# CITY OF ALBUQUERQUE

May 2, 2018

RE: **Silver Star Auto Haus**  
**5111 Wilshire Ave. NE**  
**Engineer's Stamp Date: 5/1/2018**  
**Hydrology File: C17D014A1**

Based on the information provided in the submittal received on 5/1/2018 the above-referenced Revised Conceptual Grading and Drainage Plan is approved for Site Plan for Building Permit. The following comments must be addressed prior to approval for building permit and SO-19 permit.

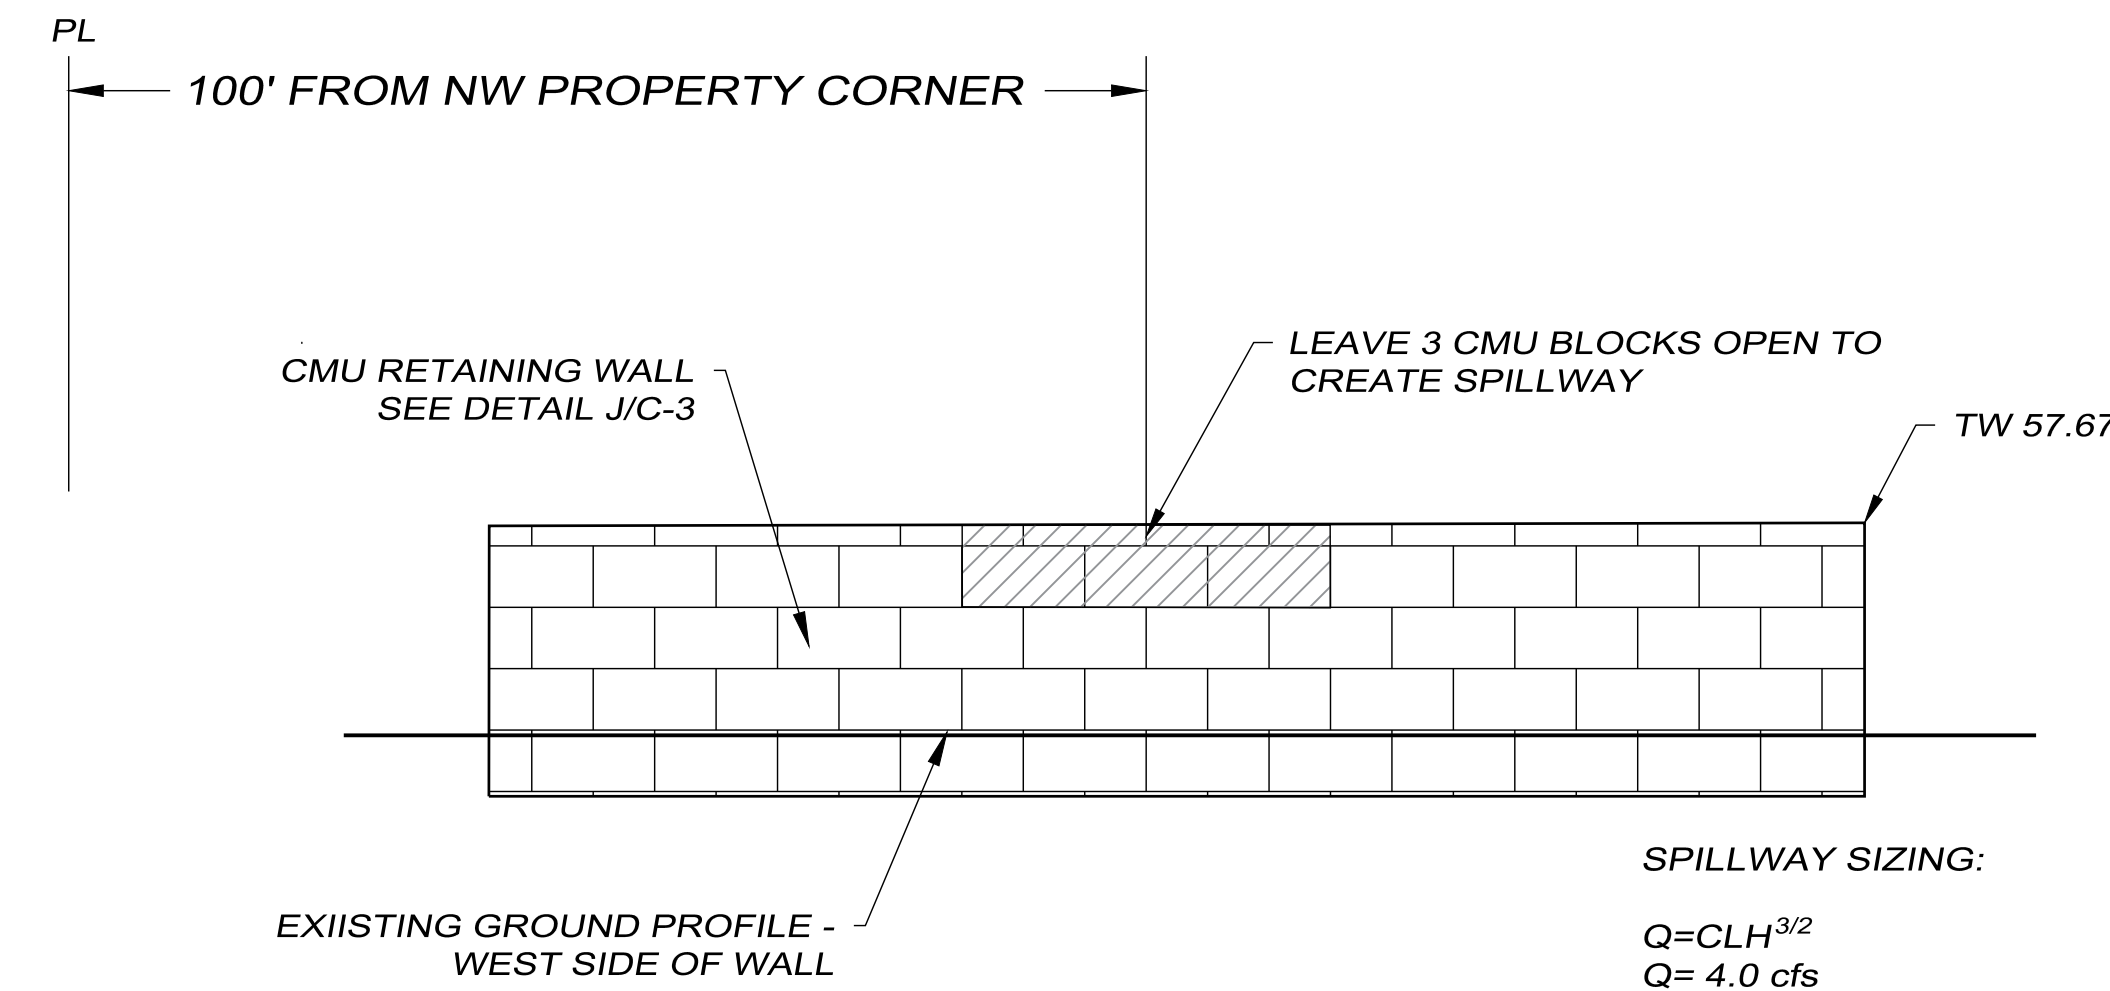
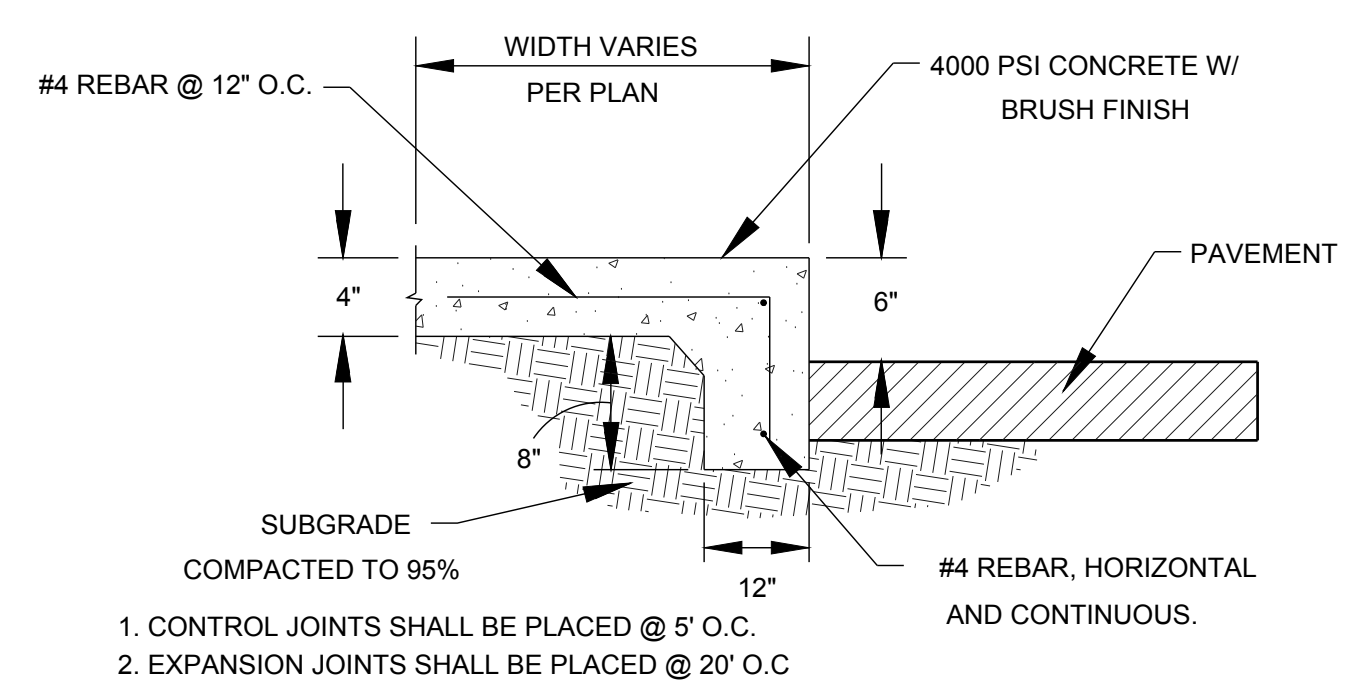
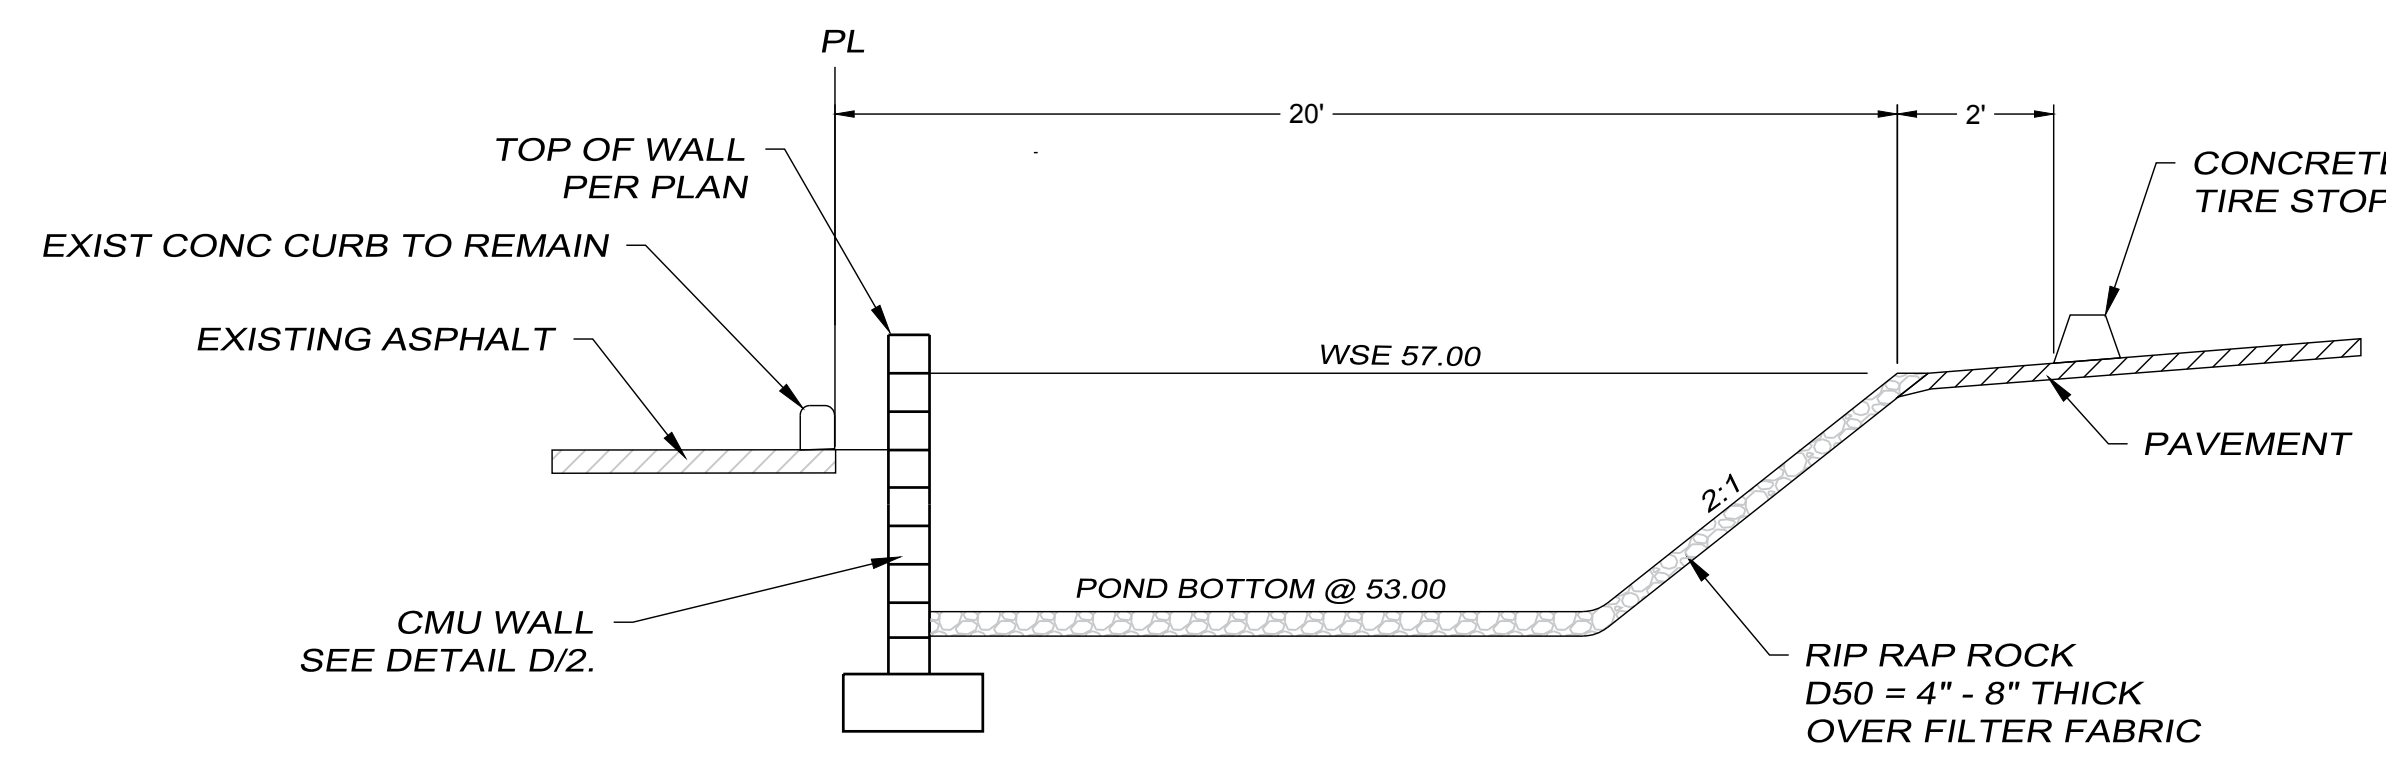
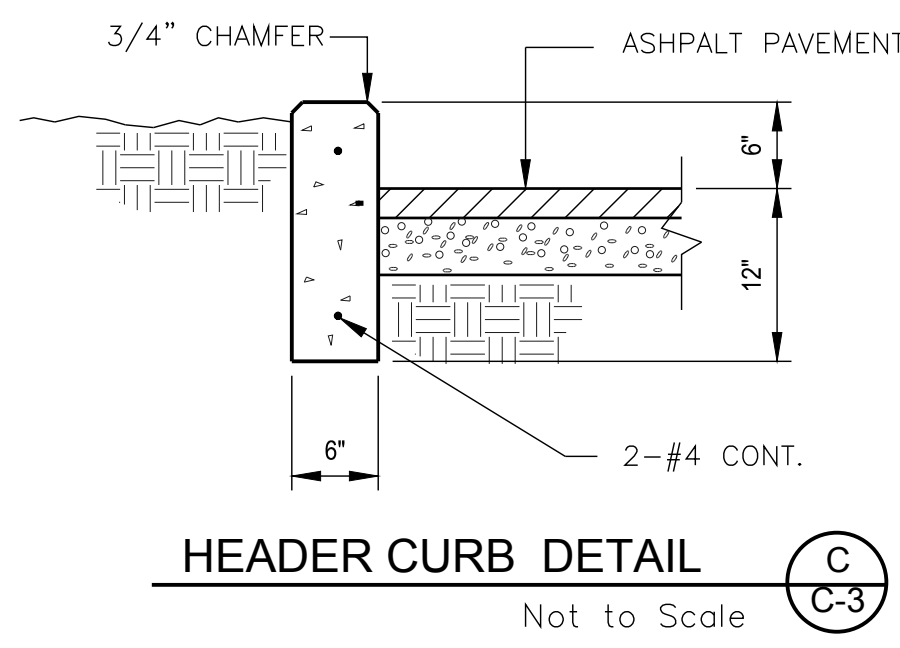
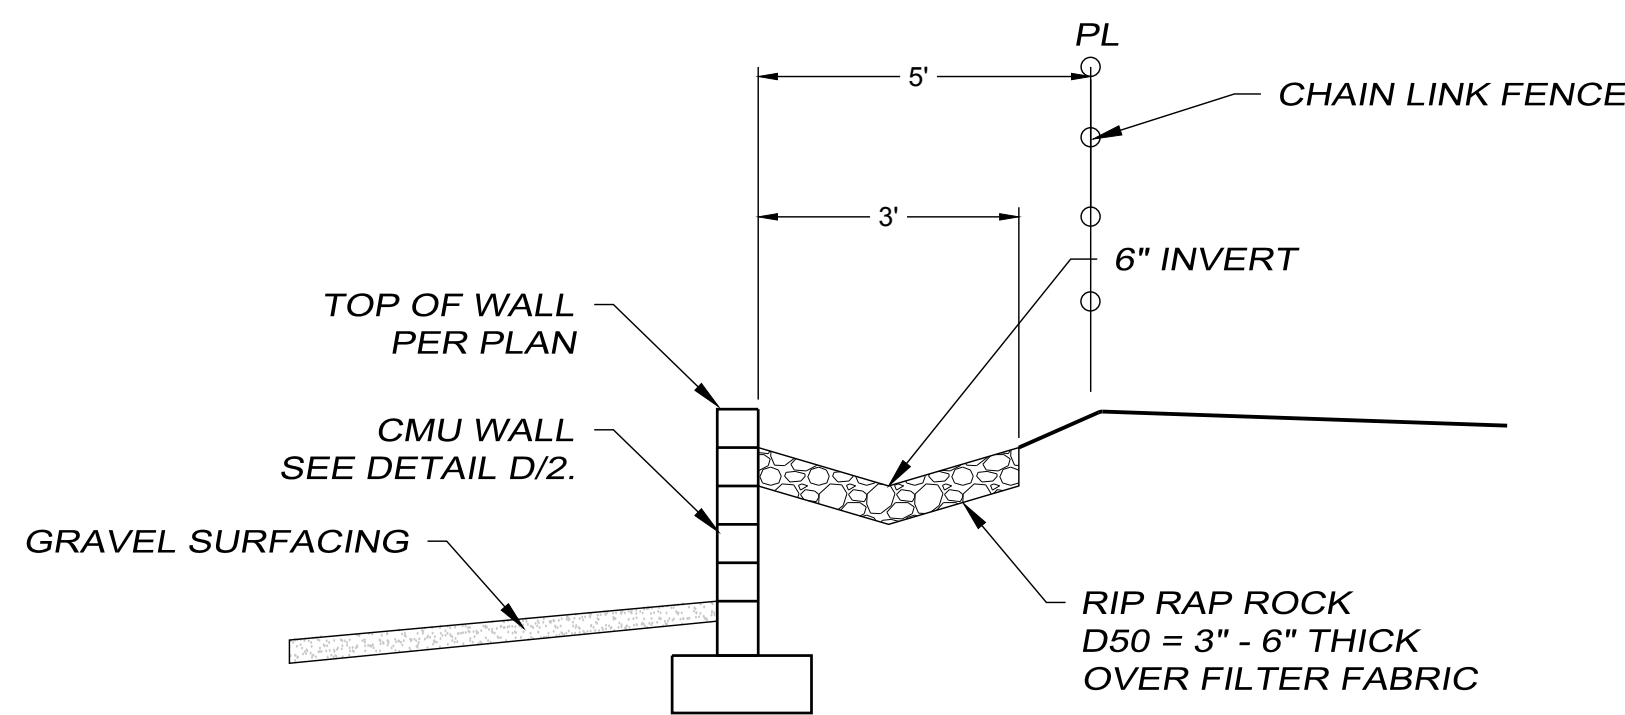
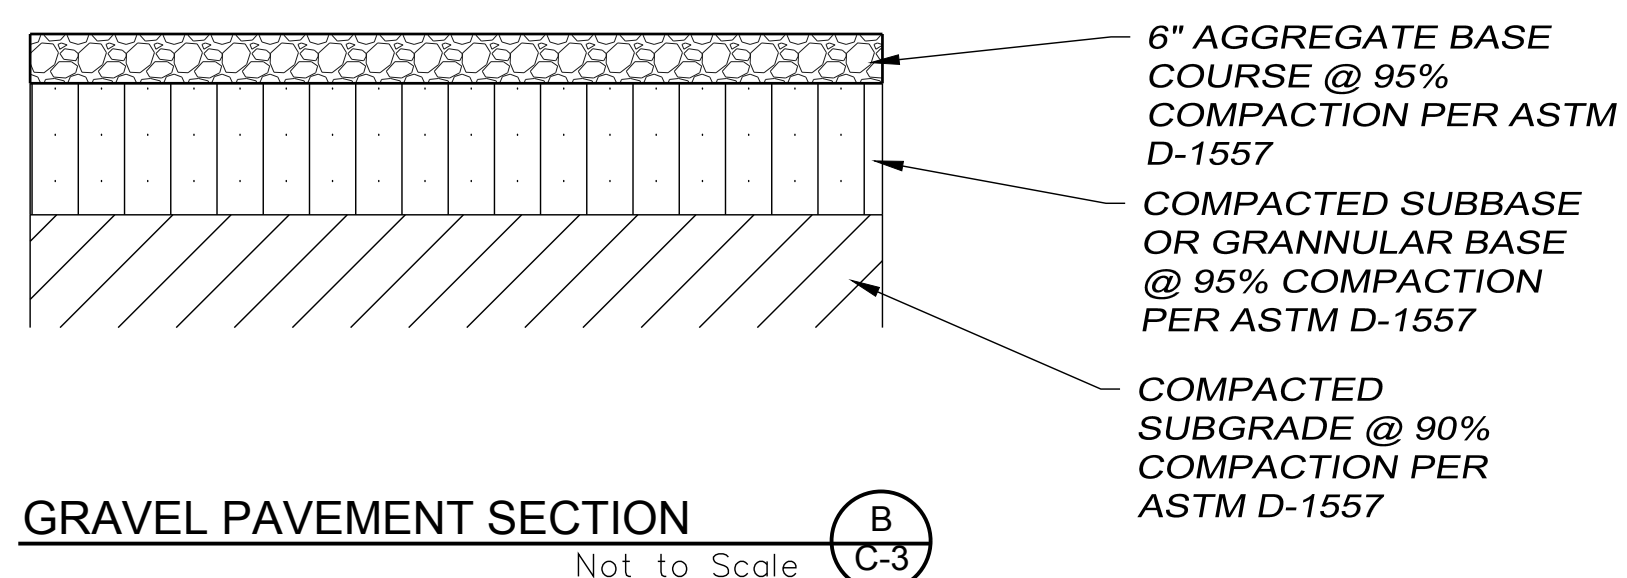
2. Add the words "see Notice to Contractor on sheet C-3" to keynote 28 on sheet C-2, and check the "SO-19 Approval" line on the DTIS.
  3. Please consider moving more of the retaining walls away from the property lines to keep the footer out of the soil friction plain, especially in front of the building where the parking spaces can easily be slid west a little. Add a note on the plan view stating that "no encroachment is allowed into the neighbor's property without written permission and any damages to the neighbor's property must be repaired". Alternatively consider adding a requirement for piling and/or shoring of the taller cuts.
